**Yorkshire Water Services
Developer Services
Sewerage Technical Team
PO BOX 52
Bradford
BD3 7AY**

**Your Ref: 2026/0374
Our Ref: B/02521**

49A Rowland Road, Old Town, Barnsley S75 2PF - (BARNS) Erection of a detached 2 storey dwelling and associated works

Title
Proposed block plan

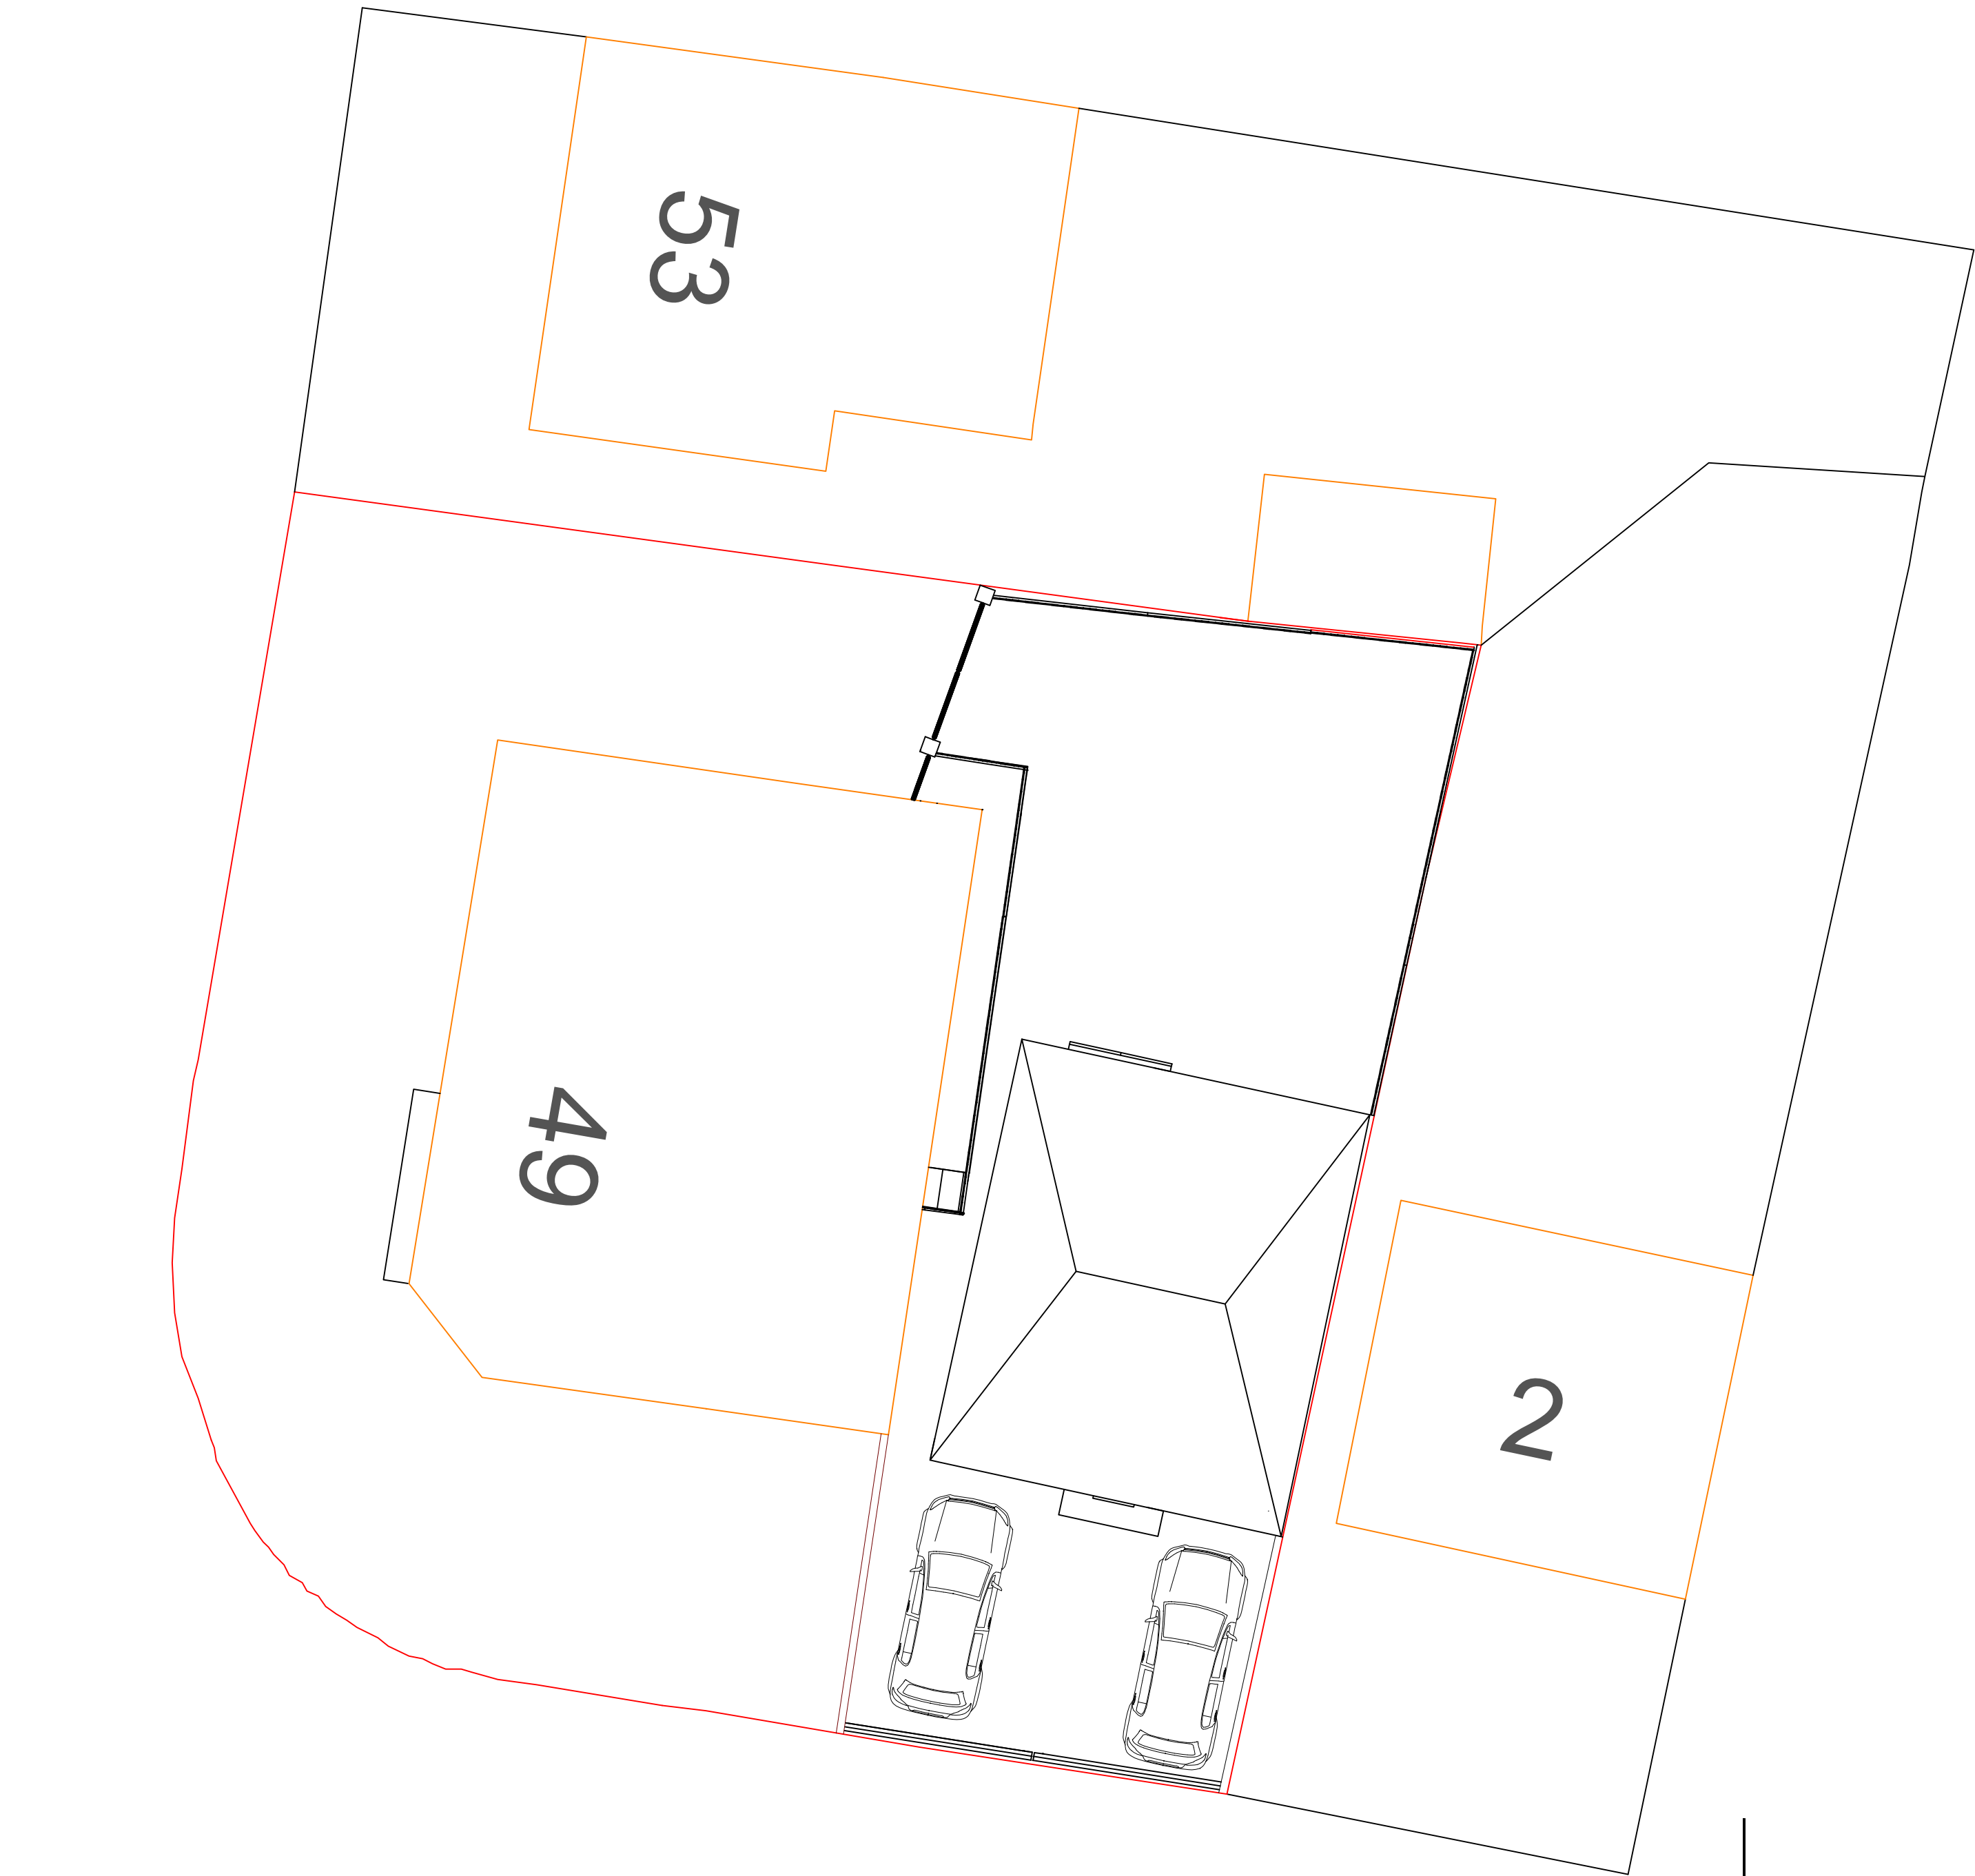
Yorkshire Water objects to the application due to lack of submitted proposed drainage details.

On the Statutory Sewer Map, there is a small diameter public combined water sewer recorded to cross the site. It is essential that the presence of this infrastructure is taken into account in the design of the scheme.

It may not be acceptable to raise or lower ground levels over the sewer and we will not accept any inspection chambers on the sewer to be built over.

Development of the site should take place with separate systems for foul and surface water drainage. The separate systems should extend to the points of discharge to be agreed.

The developer is proposing to discharge surface water to public sewer however, sustainable development requires appropriate surface water disposal.

Yorkshire Water promote the surface water disposal hierarchy, and the developer must provide evidence to demonstrate that surface water disposal via infiltration or watercourse are not reasonably practical before considering disposal to public sewer.

As a last resort, and upon receipt of satisfactory evidence to confirm the reasons for rejection of other methods of surface water disposal, curtilage surface water may discharge to public surface water sewer. Surface water discharges to the public sewer must have a minimum of 30% reduction based on the existing peak discharge rate during a 1 in 1 year storm event.

The developer will be required to provide evidence of existing positive drainage to a public sewer from the site to the satisfaction of Yorkshire Water and the Local Planning Authority by means of physical investigation. On-site attenuation, taking into account climate change, will be required before any discharge to the public sewer network is permitted.
